**KIRKLEES METROPOLITAN COUNCIL
INVESTMENT & REGENERATION SERVICE**

**DELEGATED DECISION TO DETERMINE PLANNING APPLICATION FOR
ADVERTISEMENT CONSENT**

Reference No:	2026/64/90545/W
Site Address:	adj, 42, New Street, Huddersfield, HD1 2BU
Description:	Advertisement Consent for erection of 2 digital 75inch LCD advert screens (within a Conservation Area)
Recommending Officer:	John Holmes

DECISION – ADVERTISEMENT CONSENT REFUSED

Drawing Title <b>EXISTING AND PROPOSED ELEVATIONS</b>	
Scale 1:50	Date 03/02/2026
Drawn By PTM	Checked By ABH
Drawing Number <b>003</b>	Revision <b>A</b>

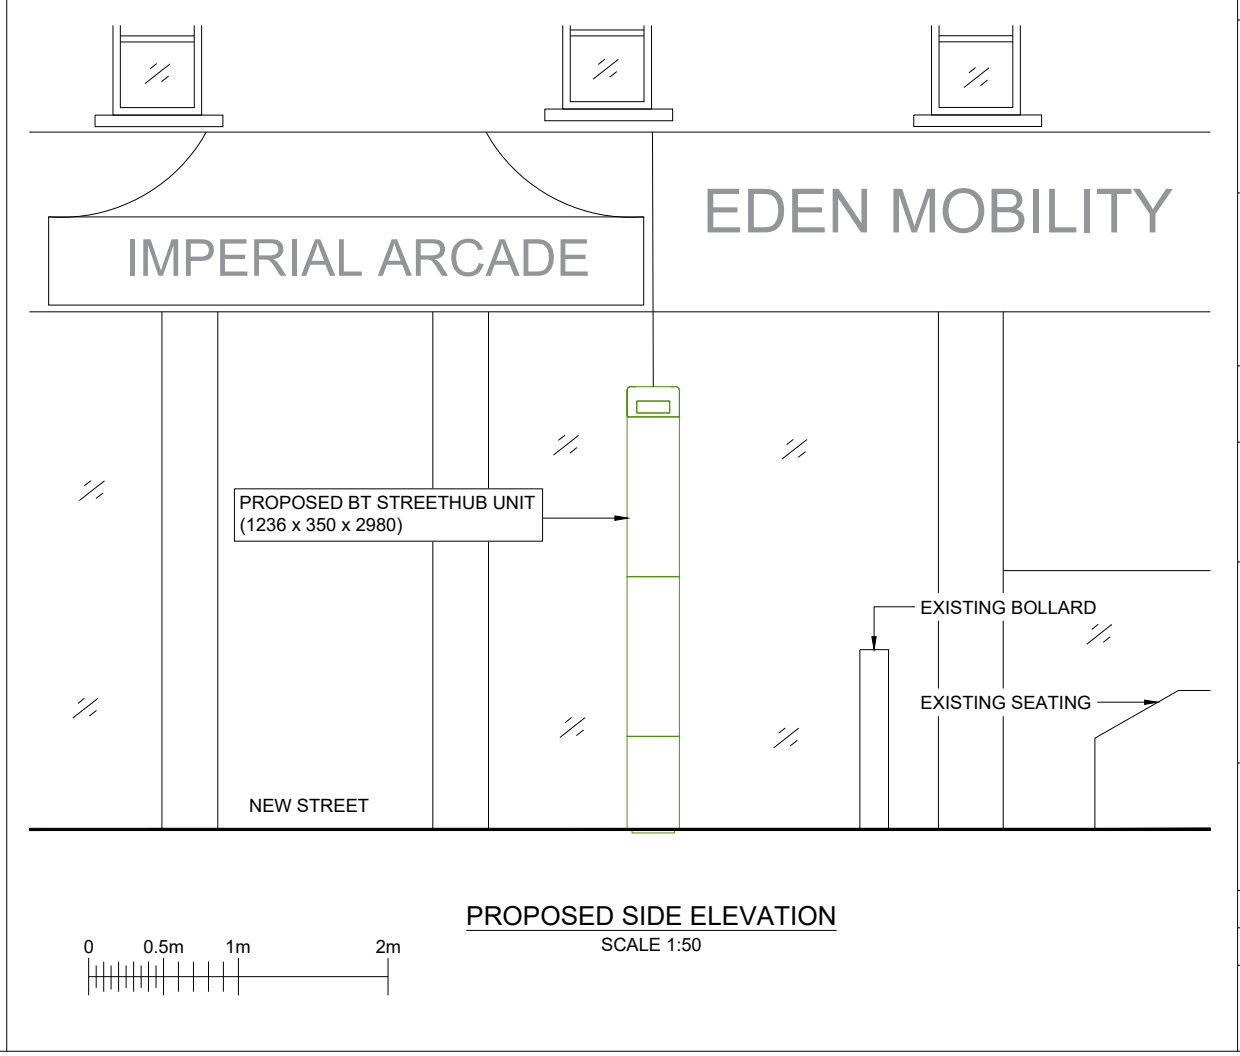
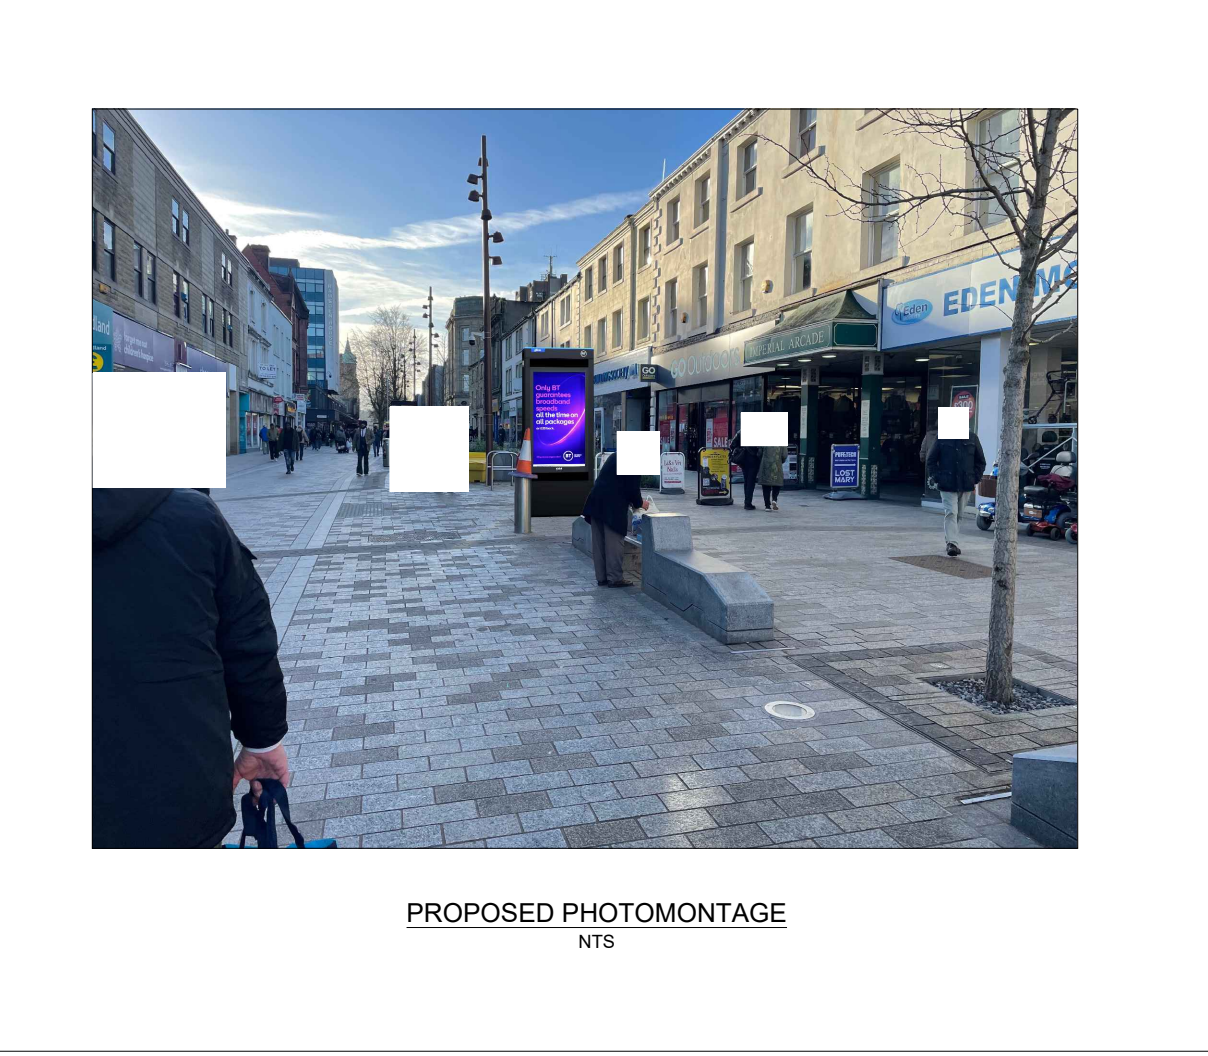
The proposed digital display screens, by reason of their scale, siting and means of illumination, would not preserve or enhance the character of the Huddersfield Town Centre Conservation Area nor that of the aforementioned Listed Buildings (in particular 33-37 King St). Whilst they would lead to less than substantial harm, it is considered that the purported public benefits would not outweigh the harm caused in this instance.

The proposed digital display screens, owing to their scale, prominent siting, and means of illumination, would be a visually incongruous and intrusive feature that would cause harm to the significance of the adjacent Huddersfield Town Centre Conservation Area and to the settings of adjacent Listed Buildings. The harm caused to designated heritage assets would be less than substantial. The public benefits associated with the proposed development would not, however, outweigh the harm caused. In addition, the proposal would add further illuminated street clutter which would detract from the character of the wider Town Centre, and would prejudice the aims of the
